EPC STORMWATER REVIEW COMMENTS ARE
SHOWN IN ORANGE BOXES WITH BLACK TEXT

LOTS 3, 4, AND 5 NORTHCREST CENTER FILING NO 2
PHASE 1 SUBDIVISION
REFERRED TO AS: “NORTHCREST CENTER”
FINAL DRAINAGE REPORT

PCD FILE NO. PPR-21-036

November 8, 2021

BASIN SUMMARY			
BASIN	$Q(5)$ -CFS	$Q(100)$ -CFS	ACRES(AC)
E-1	0.81	5.27	3.24

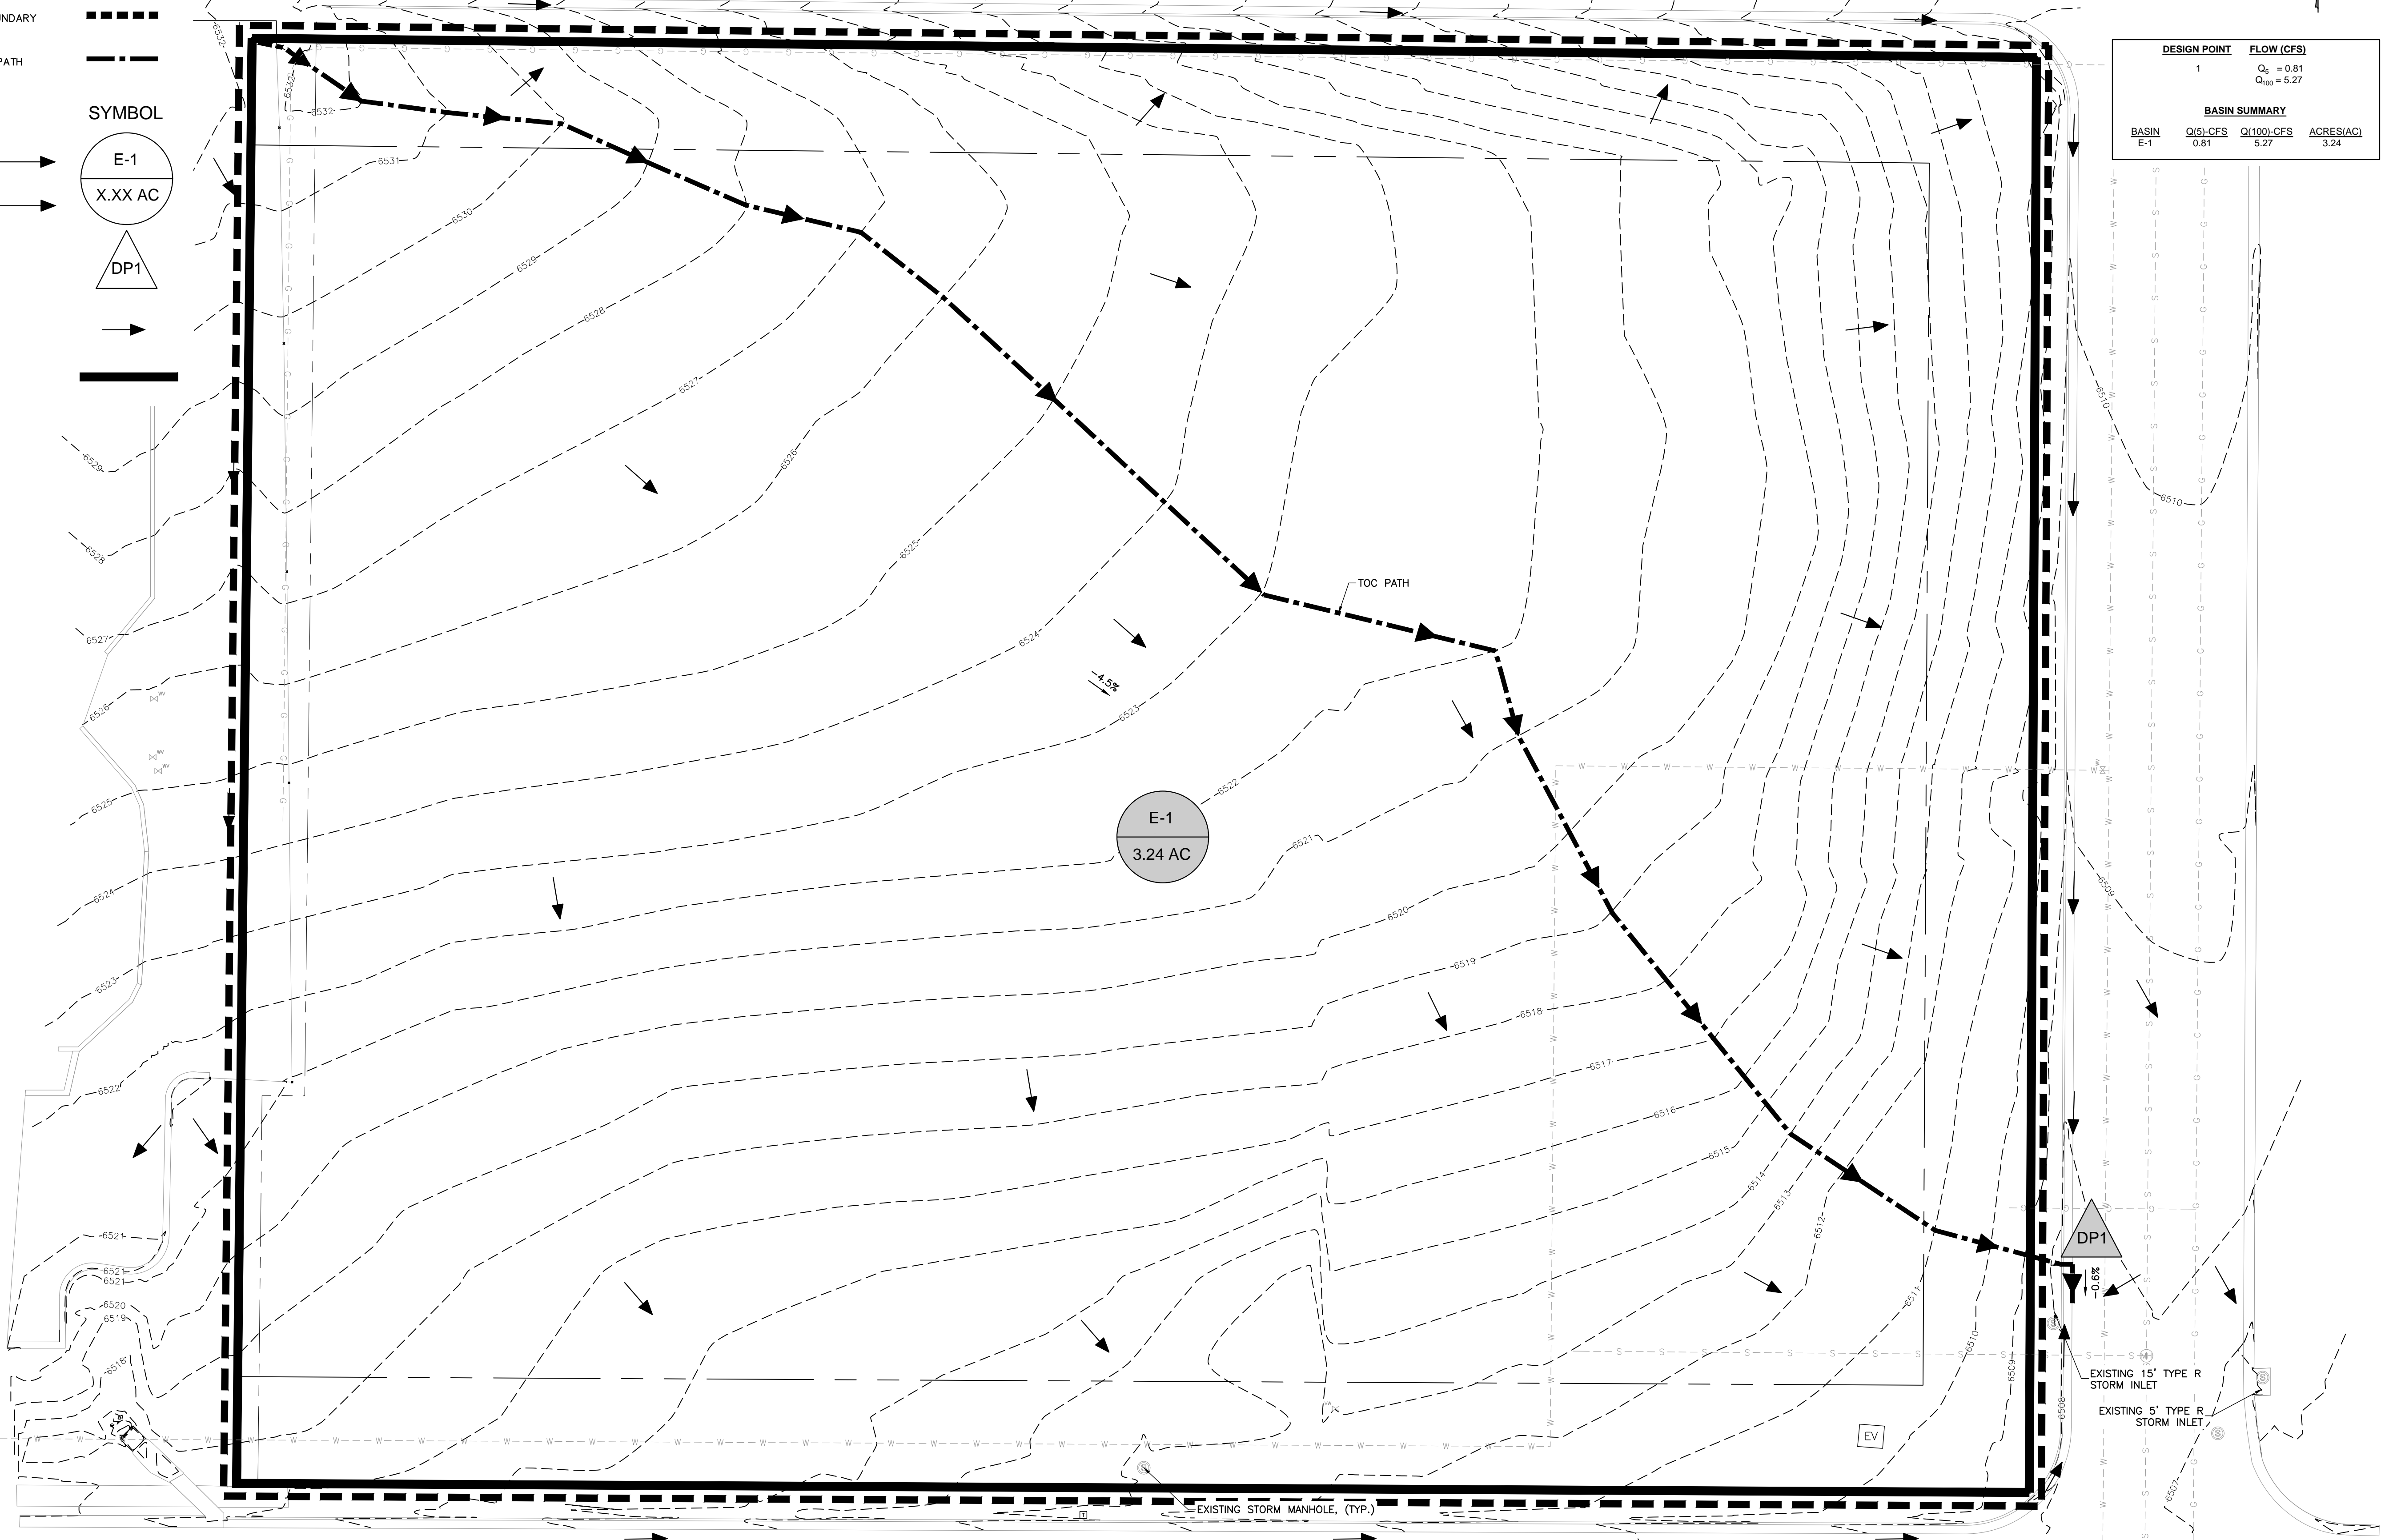
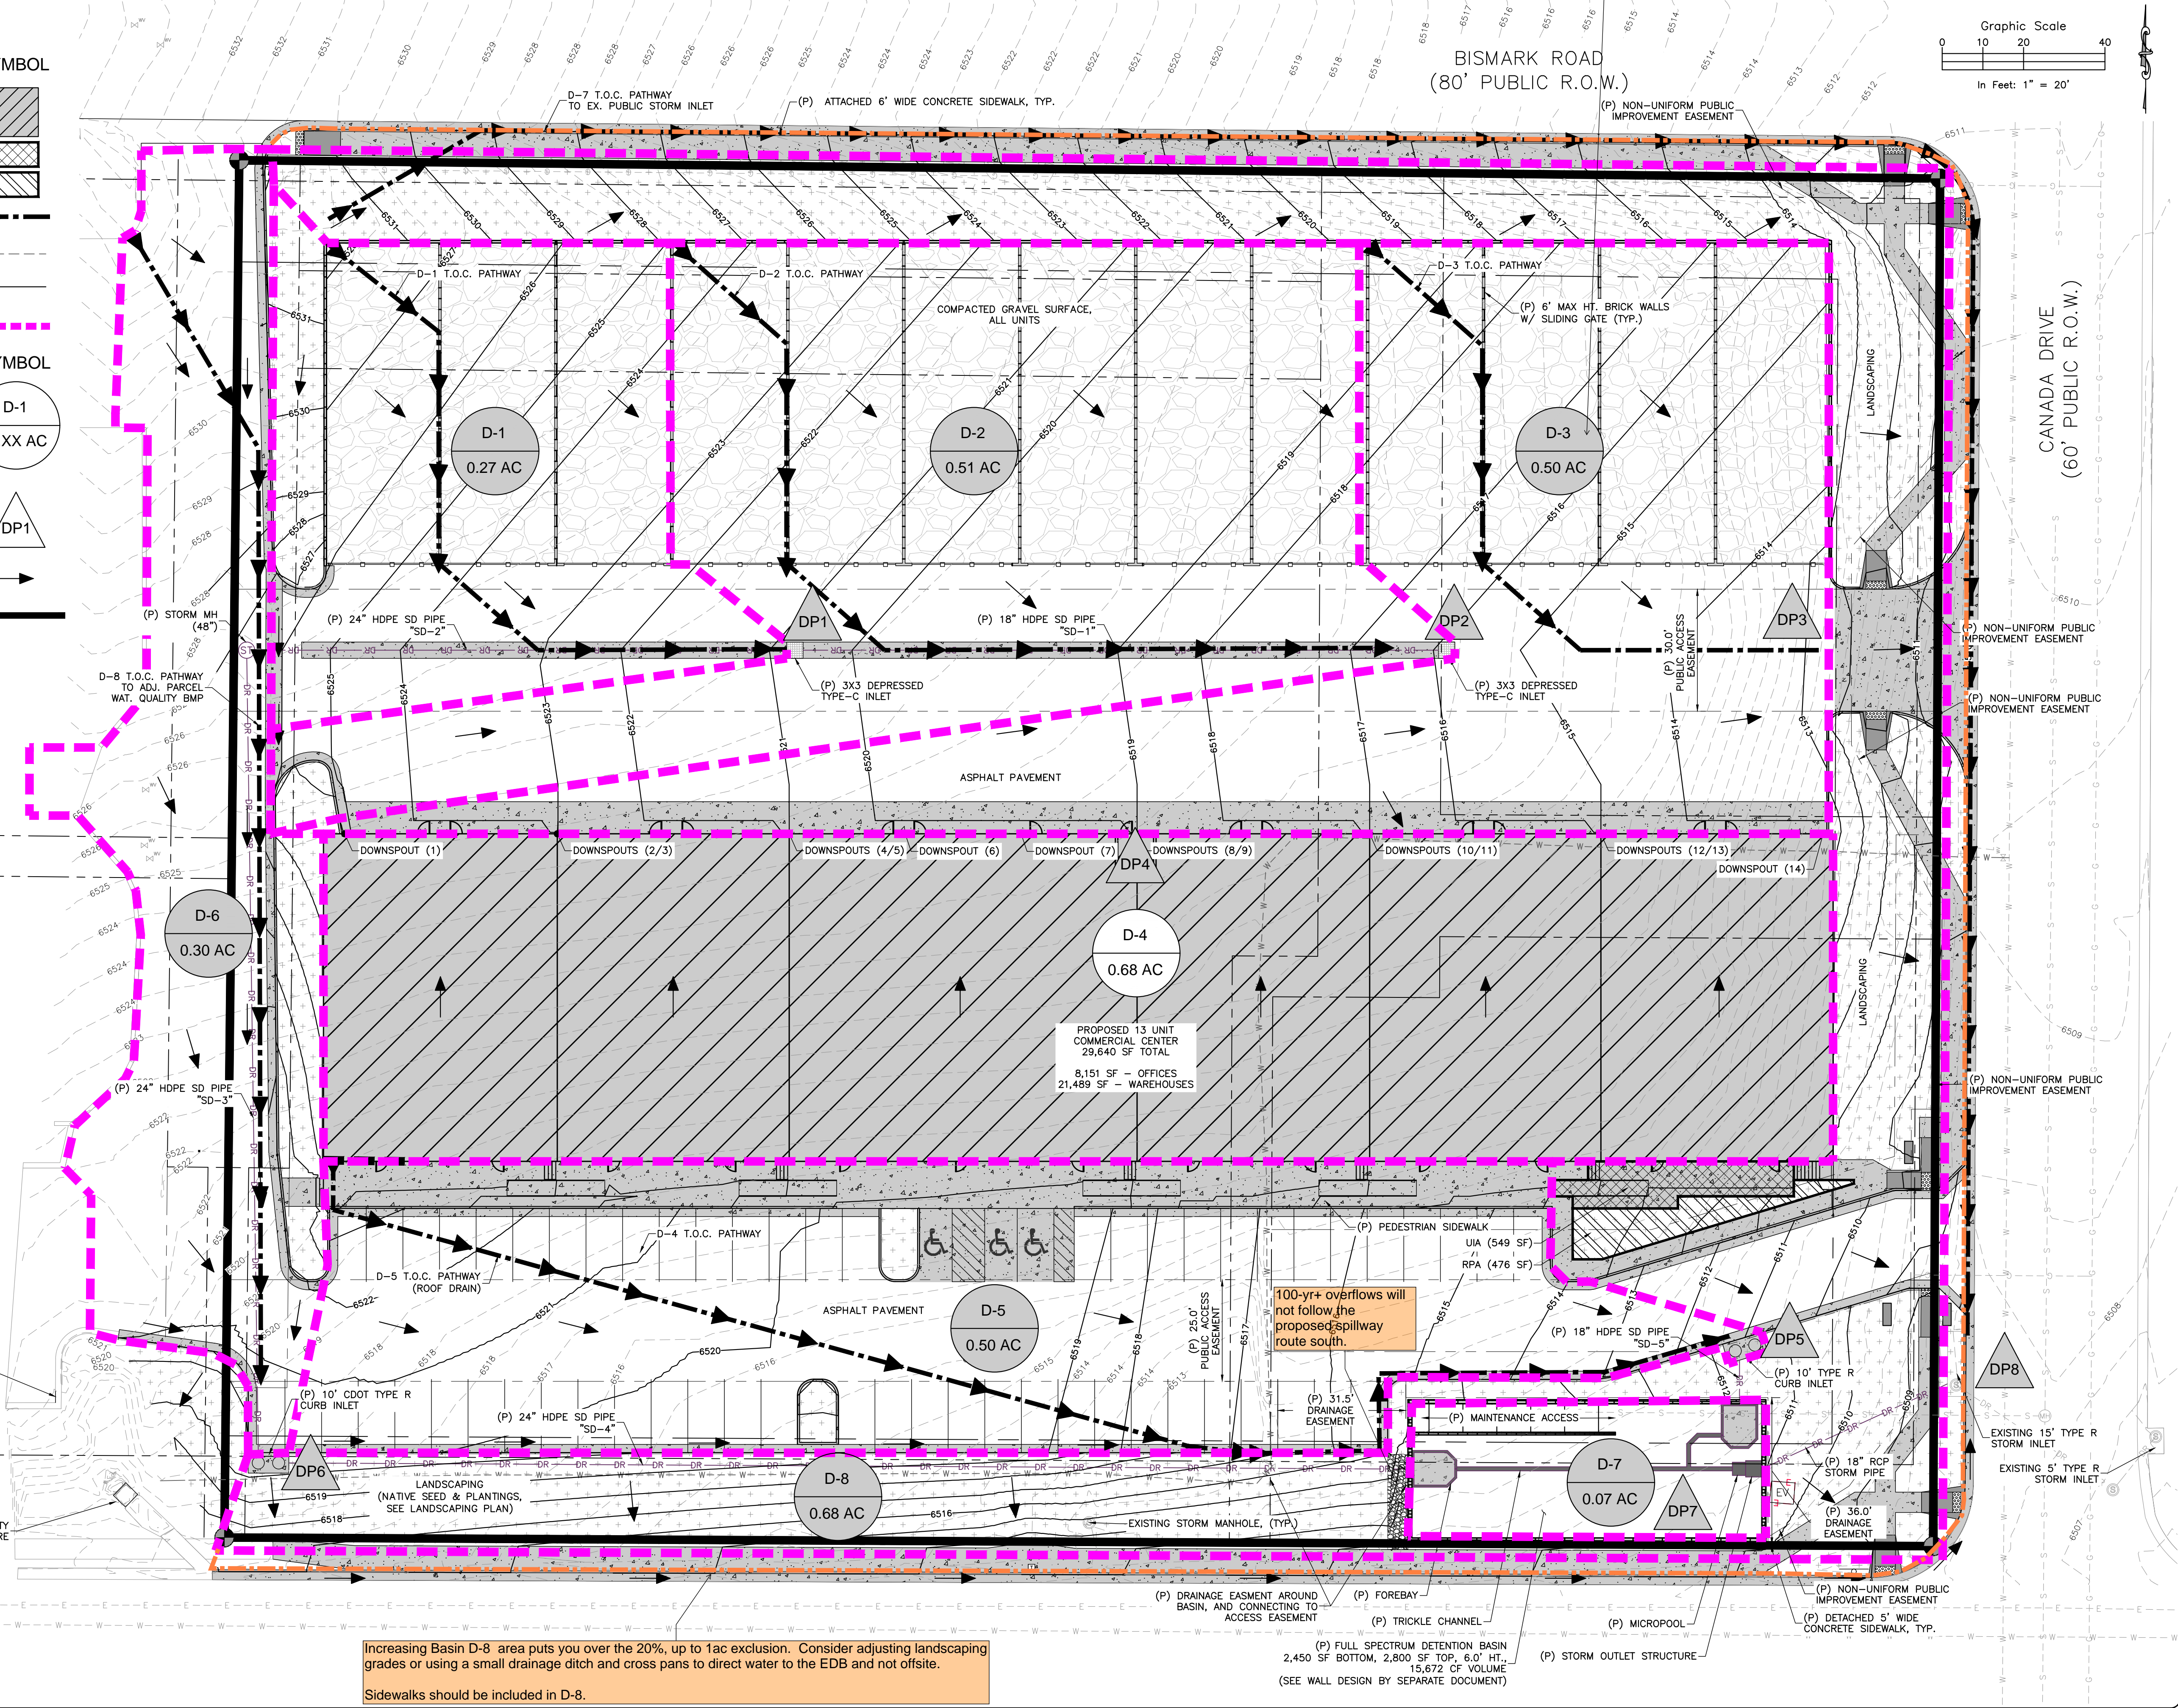
Based on proposed contours, water will spill onto sidewalk before entering EDB.

Appropriate spillway needs to be constructed, cannot just overflow sidewalls of pond

confirm that this offsite WQ Pond was sized for inflow from the Site. Provide UD Detention Form
